Application No: A/266/21/PL
Site Address: Crete House The Beeches Dappers Lane Angmering BN16 4EN
Description of works: 2 No. 2 storey extensions, replace existing bay window with bi-fold doors on the existing dwelling and the construction of 2 No. 5 bed new dwellings. This application is in CIL Zone 2 and is CIL liable as new dwellings.

Thank you for your internet representation made on 16th February 2022 which has been recorded as an objection with the comments as follows:

SITE PLAN & VISIBILITY SPLAY
1:200

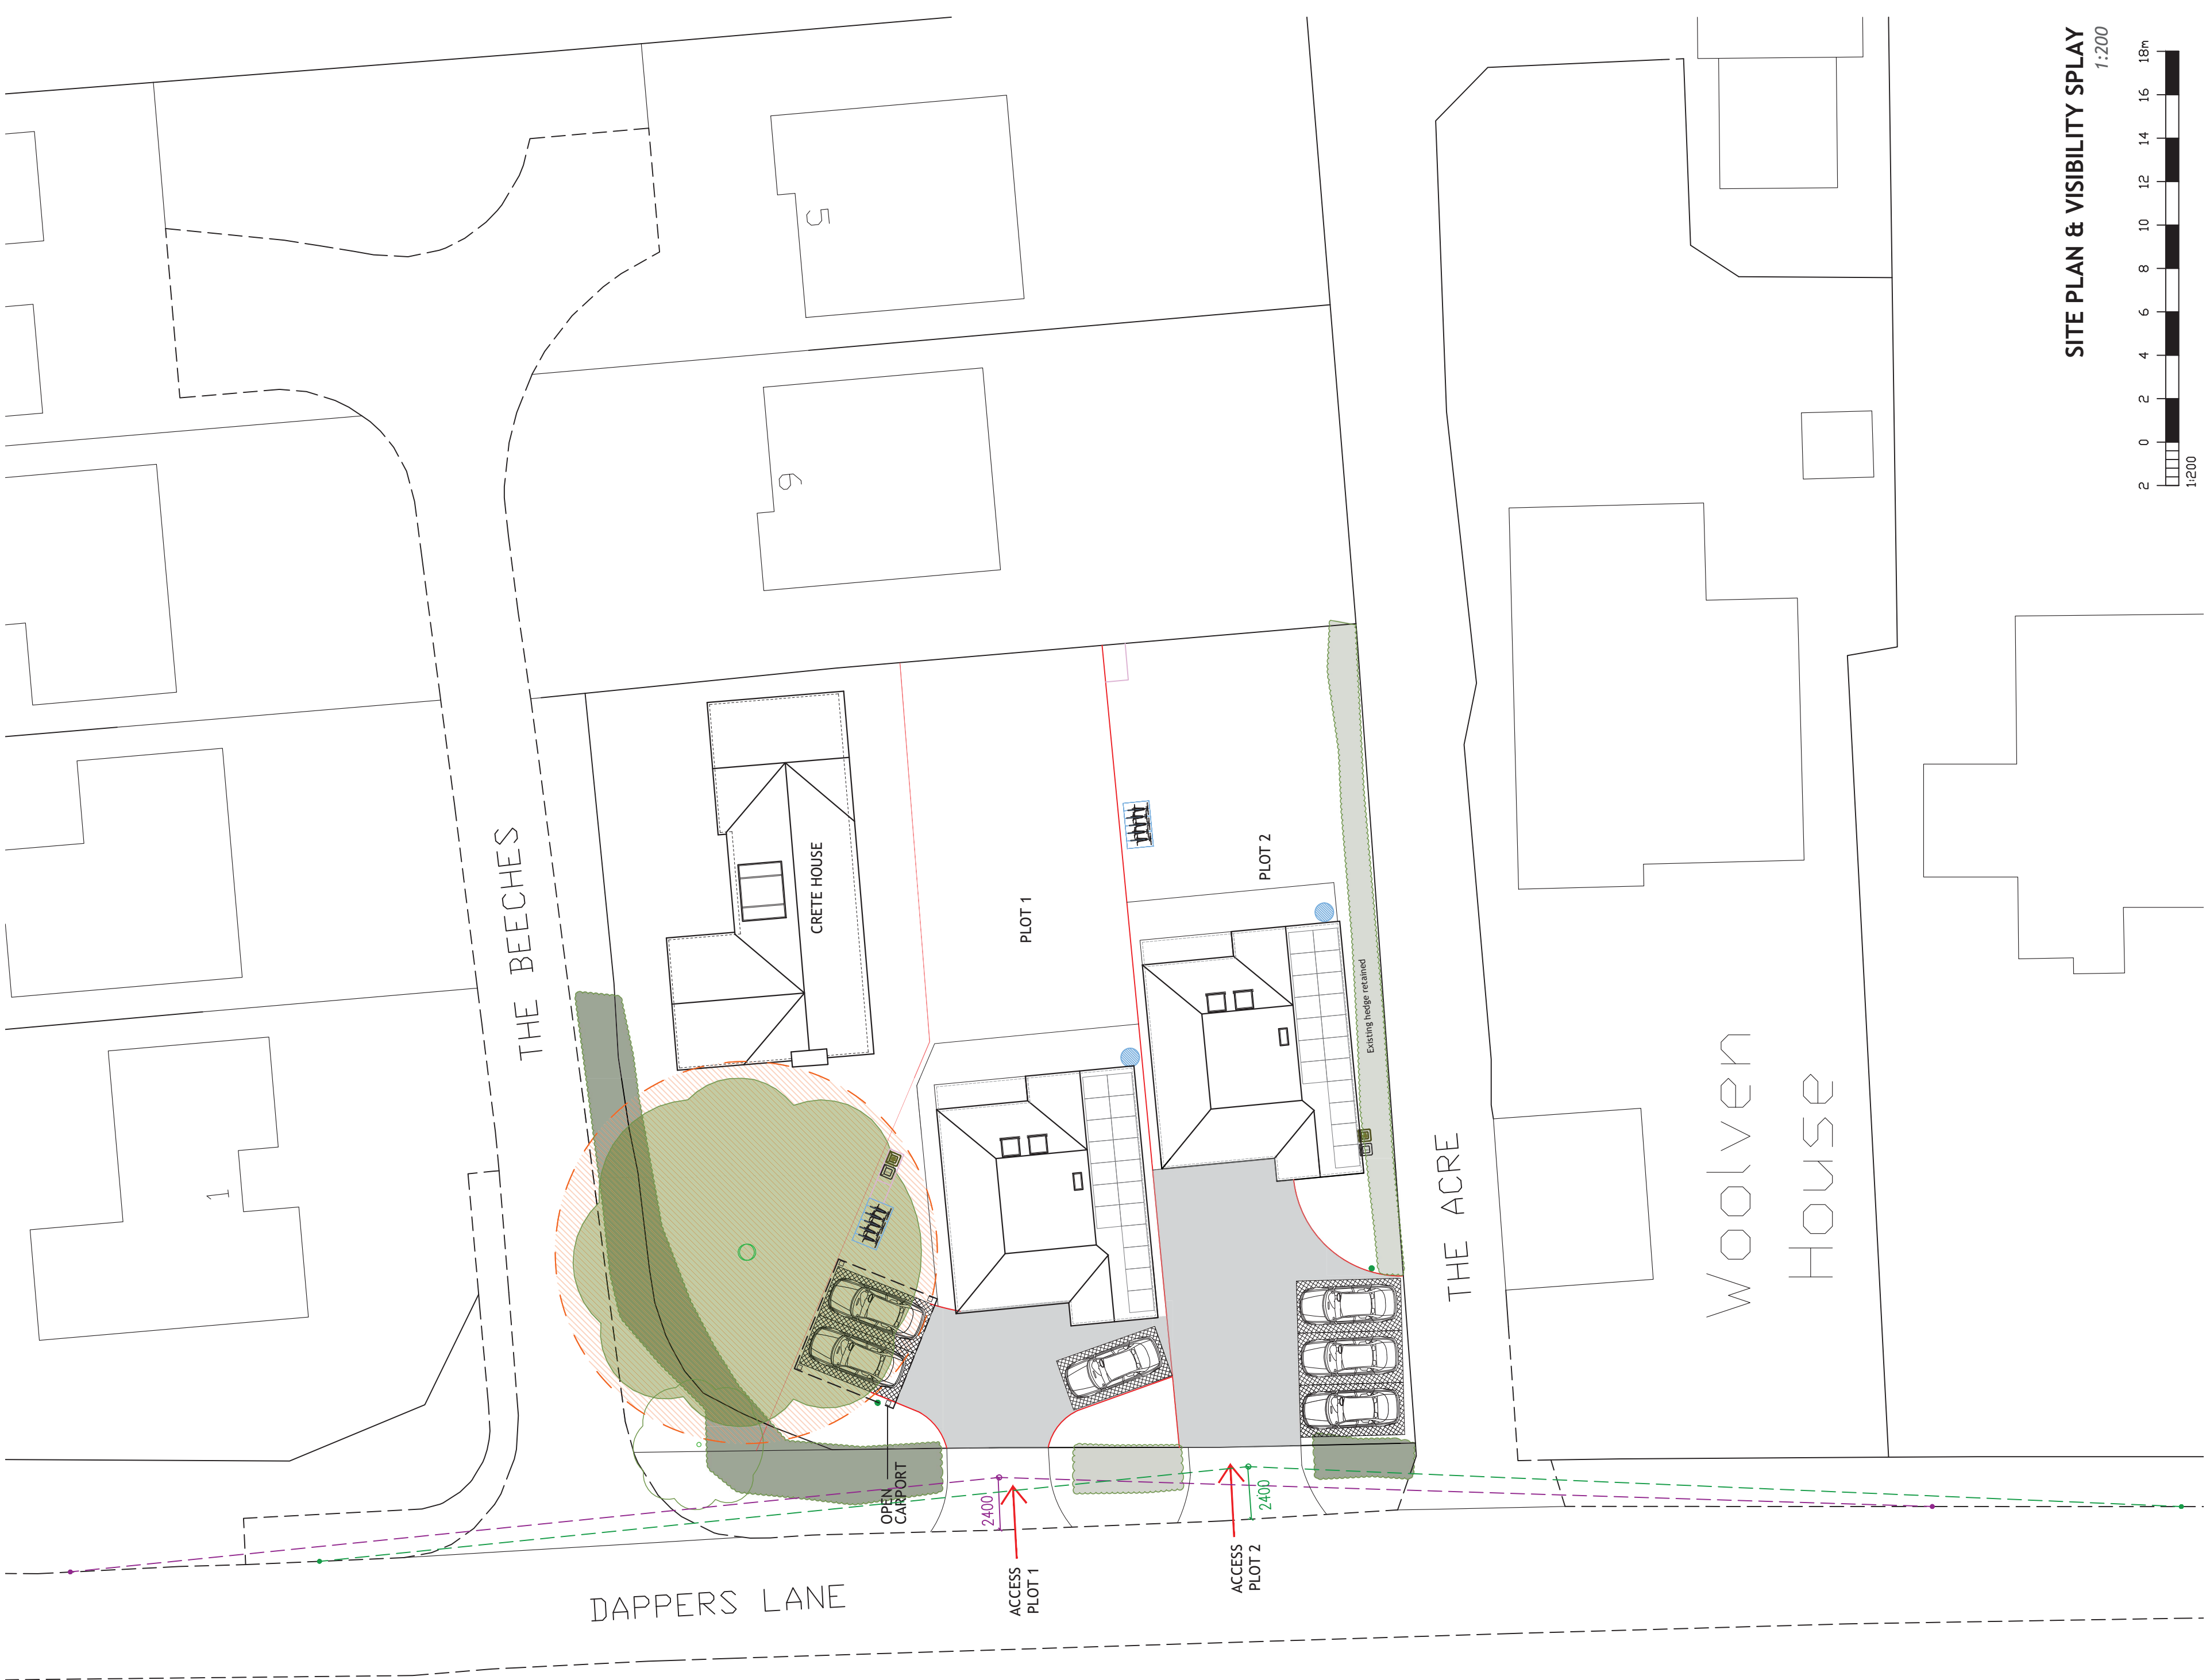
2. The large oak tree has a TPO. The proposed development of parking directly next to the tree will potentially destroy the trees root system. This could kill the tree which of course is totally unacceptable, even more so as this is one of the last remaining mature oak trees on Dappers Lane.

4. The adverse impact on highway and pedestrian safety. The proposed new properties have only one entry / exit point for up to 8 cars to use. This entry point is too close to the existing entry / exit point to the Beeches and to the industrial estate, impacting the required 43 metre splays and disturbing land privately owned by the residents of the Beeches.

DRAWING
PROPOSED ELEVATIONS
PROPOSED BLOCK PLAN

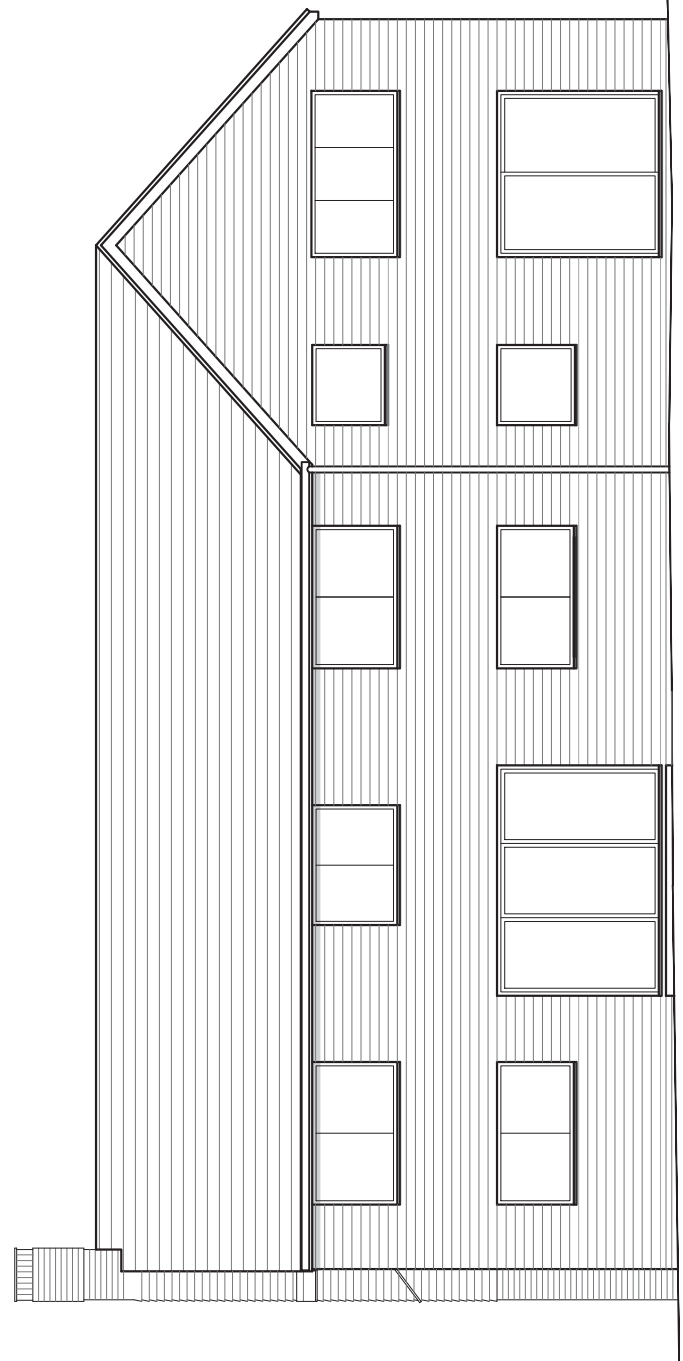
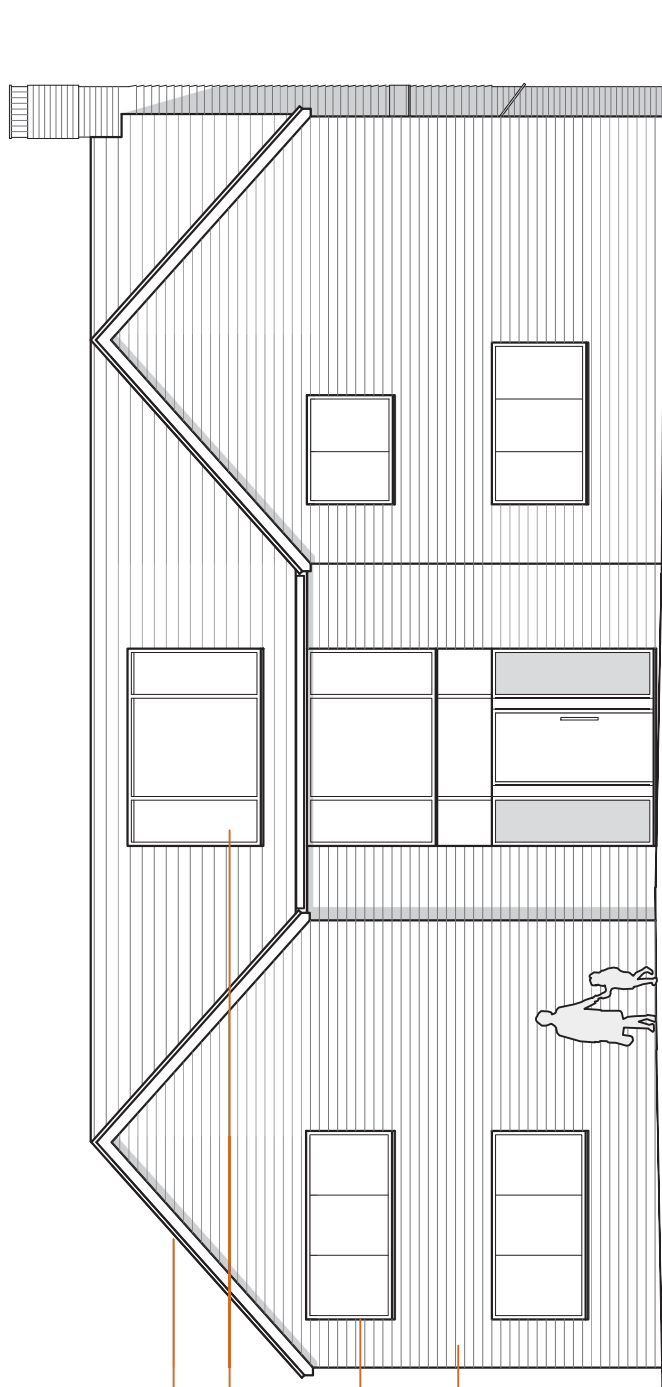
3. The severe harm on the residential amenity of neighbouring properties. The proposed extension of Crete House adds many more square metres of glazing with additional views directly into the private bedrooms of

adjacent properties at number 1,2 and 3 the Beeches, This unacceptable increase in overlooking, overbearing buildings is a severe intrusion into our privacy.
